DEVELOPMENT REVIEW BOARD
TRANSPORTATION DEVELOPMENT

DRB Project Number: 1011435
Fineland Development – Kidz Academy

SUBJECT: EPC Approved Site Plan for Building Permit

DRB Project Number: 1011435 Hearing Date: 04-11-2018
 Project: Kidz Academy Agenda Item No: 5

SITE PLAN

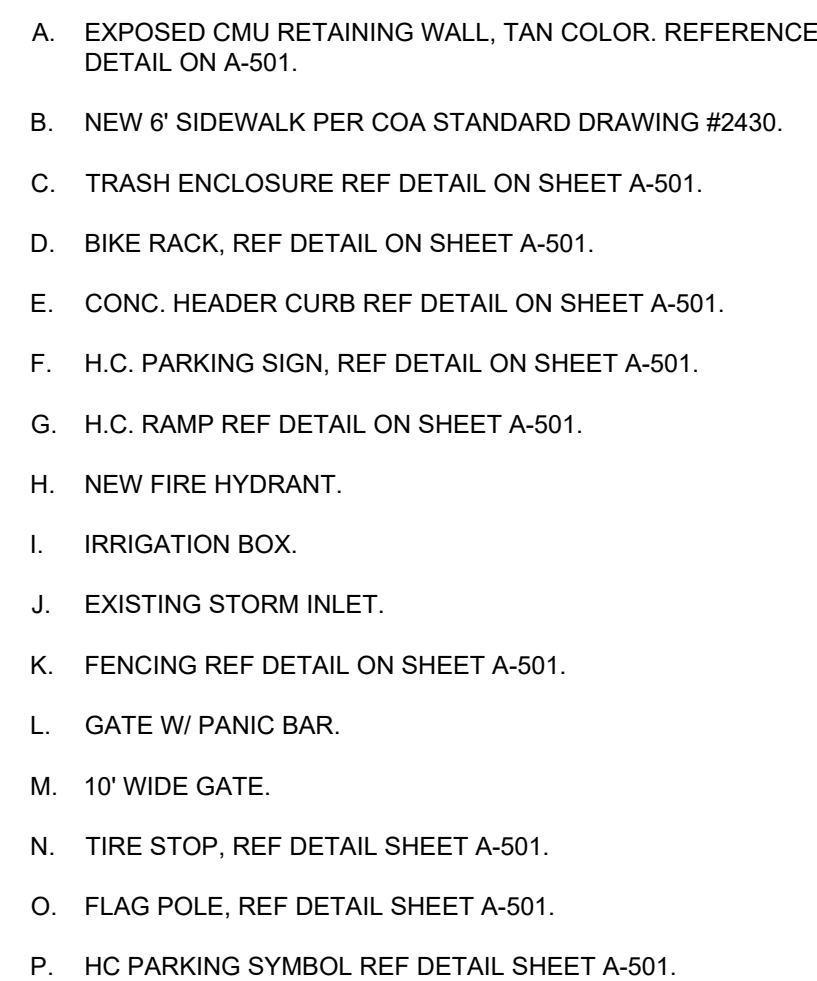
1. Infrastructure list should include all frontage improvements including ¼ signal.
2. Perform an overall quality control check. (Street names are missing, dimensions are obscured, keyed notes are very large, PNM easement looks like an access etc.)

3. Please add a note on the plan stating "All improvements located in the Right of Way must be included on a public work order."
4. Please add the clear sight triangle to each subdivision entrance. Add the following note as well: "Landscaping, fencing and signing will not interfere with clear sight requirements. Therefore, signs, walls, trees, and shrubbery between 3 and 8 feet tall (as measured from the gutter pan) will not be acceptable in the clear sight triangle."

5. The ADA access aisle shall have the words "**NO PARKING**" in capital letters, each of which shall be at least one foot high and at least two inches wide, placed at the rear of the parking space so as to be close to where an adjacent vehicle's rear tire would be placed. (66-1-4.1.B NMSA 1978)

6. List the number of parking spaces required by the zoning code as well as the proposed number of parking spaces including bicycle and motorcycle parking.

7. Identify all existing access easements and rights of way width dimensions.
8. Clarify existing property lines and proposed property lines. Provide plat.

9. Please list the width and length for all existing and proposed parking spaces. Some dimensions are not shown.
10. Per the zoning code, a 6 ft. wide ADA accessible pedestrian pathway is required from the public sidewalk to the building entrances. Please clearly show this pathway and provide details.

11. Add parking bumpers where the curb ramp is located. Show where the curb ramp is located.
